## KITTITAS COUNTY COMMUNITY DEVELOPMENT SERVICES

**Subject: Palomino Fields, Division 7 (LPF-21-00008) Final Long Plat – Staff Review, Return of Application- Additional Information Required.**

**KITKITAS COUNTY DEPARTMENT OF PUBLIC WORKS**  
EXAMINED AND APPROVED  
This ..... day of ..... A.D., 2021  
Kitkitas County Engineer

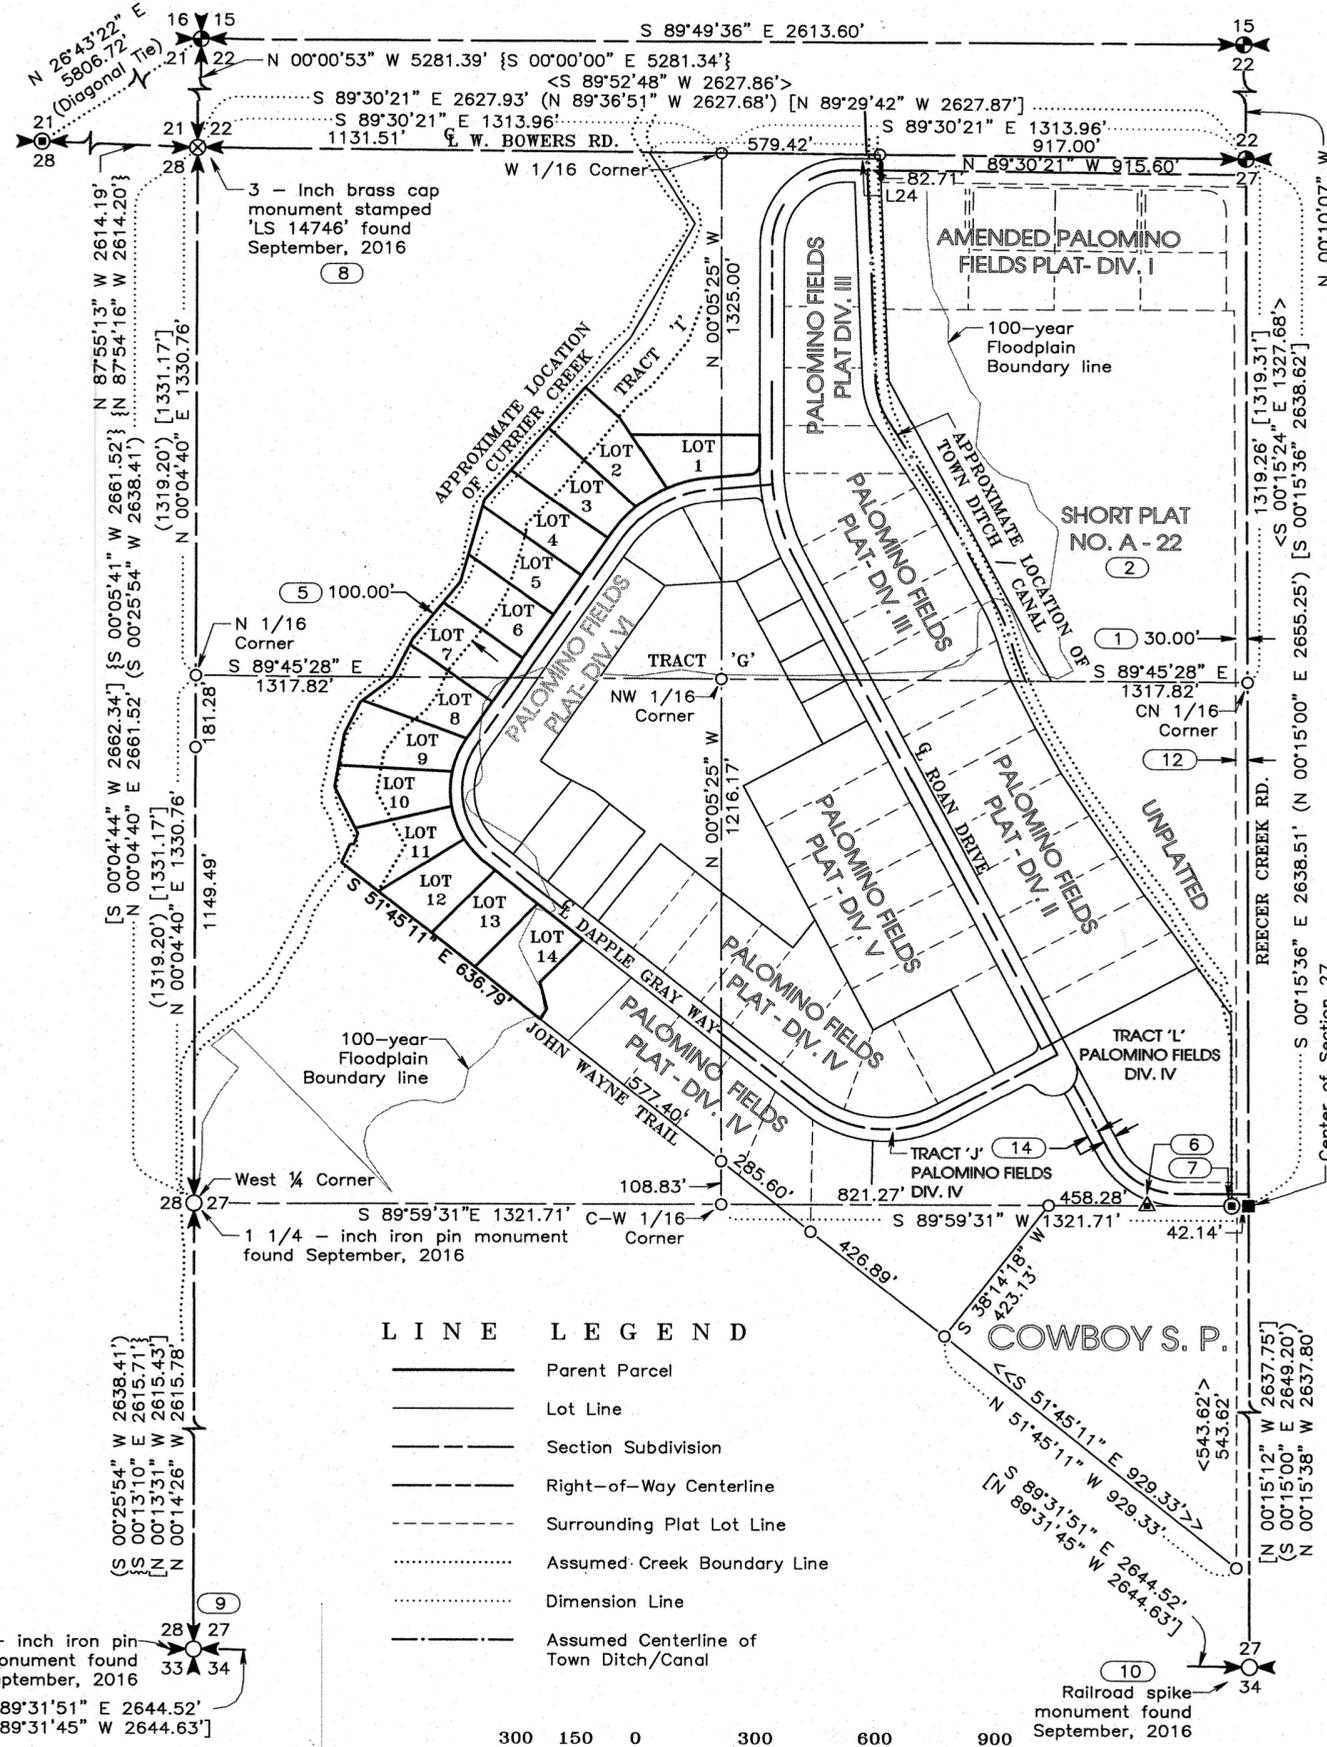
- The final mylars shall note the final plat file number LPF-21-00008 on the face of the plat in addition to the preliminary approval number LP-07-00031.
- Taxes on parcel #961599 must be paid in full before final signature.
